**REQUEST FOR EPA COMMENT – SYDNEY METRO (CHATSWOOD TO SYDENHAM) (SSI 7400)
MODIFICATION 5 – BLUES POINT ACOUSTIC SHED**

I refer to the request from the Department of Planning and Environment (DPE) to the NSW Environment Protection Authority (EPA) dated 3 September 2018 to undertake a review of the proposed modification to the Sydney Metro City and Southwest (Chatswood to Sydenham) rail project SSI 7400 Modification 5.

Construction Noise Predictions Worst-case NML Exceedance Excavation with Shed - Evening

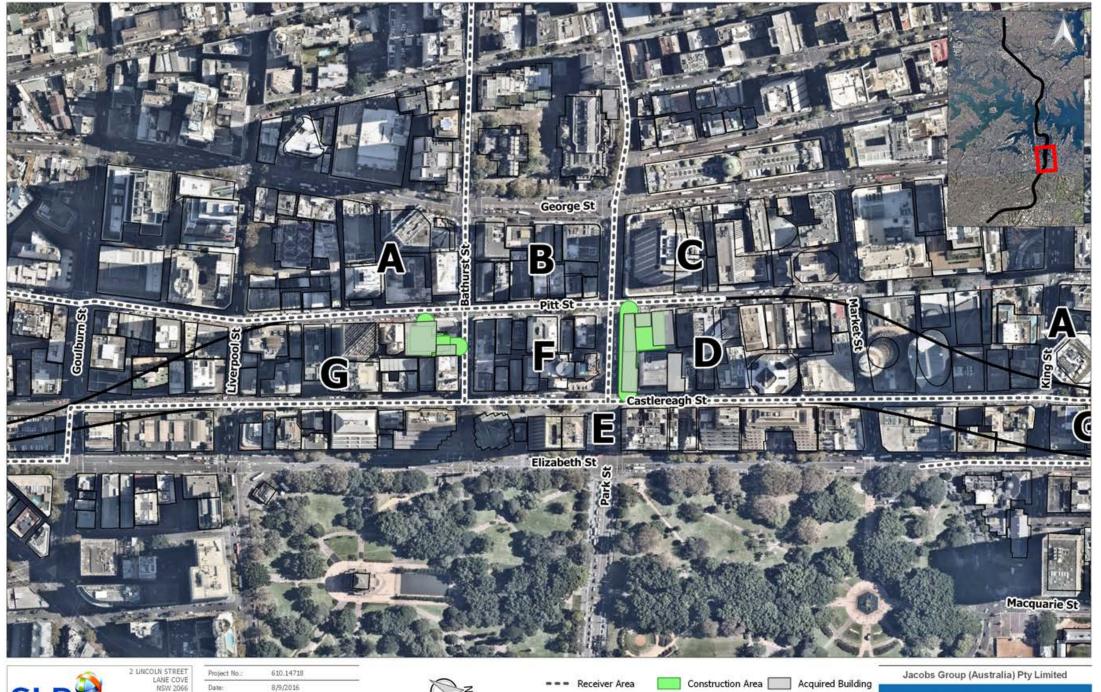
- CSSI CoA E48 permits 24/7 operation for “*excavation within an acoustic enclosure*”. Construction of the acoustic shed will therefore permit 24/7 excavation at the Blues Point worksite. While the application highlights the benefits (noise attenuation) provided by the acoustic shed, it does not fully consider the fundamental impacts associated with out of standard hours excavation. The Modification Report, August 2018 (“the modification report”), section 8.3 states: “*Bulk shaft excavation within the acoustic shed has the potential to exceed the NML by approximately 10dBA*”. It is clear that out of standard hours excavation will have noise impacts. Therefore the need and justification for 24/7 excavation should be considered before determination of the application.

- The Noise Management Levels (NMLs) presented in the modification report adopt night time values based on external equivalent noise levels derived from CSSI CoA E42. It is the EPA’s position that condition E42 does not replace the NMLs derived from the *Interim Construction Noise Guideline (ICNG - EPA,2009)* for the purposes of determining potential impacts from a proposal. The purpose of condition E42 is to mandate a level above which mitigation measures in the *Sydney Metro City and South West Noise and Vibration Strategy* are to apply. The EPA’s position is that the ICNG should be used to determine potential impacts from the proposal.

Figure 2 | Section details of acoustic shed

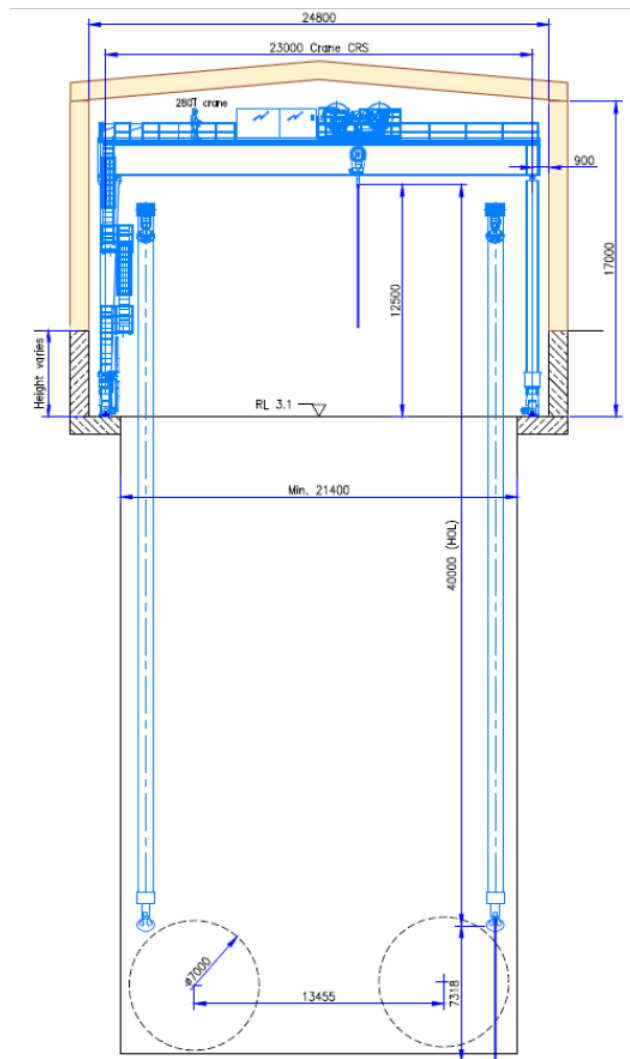
- The construction of the acoustic shed will have associated construction noise impacts. Construction of the shed should be limited to standard construction hours outlined in CSSI CoA E36.
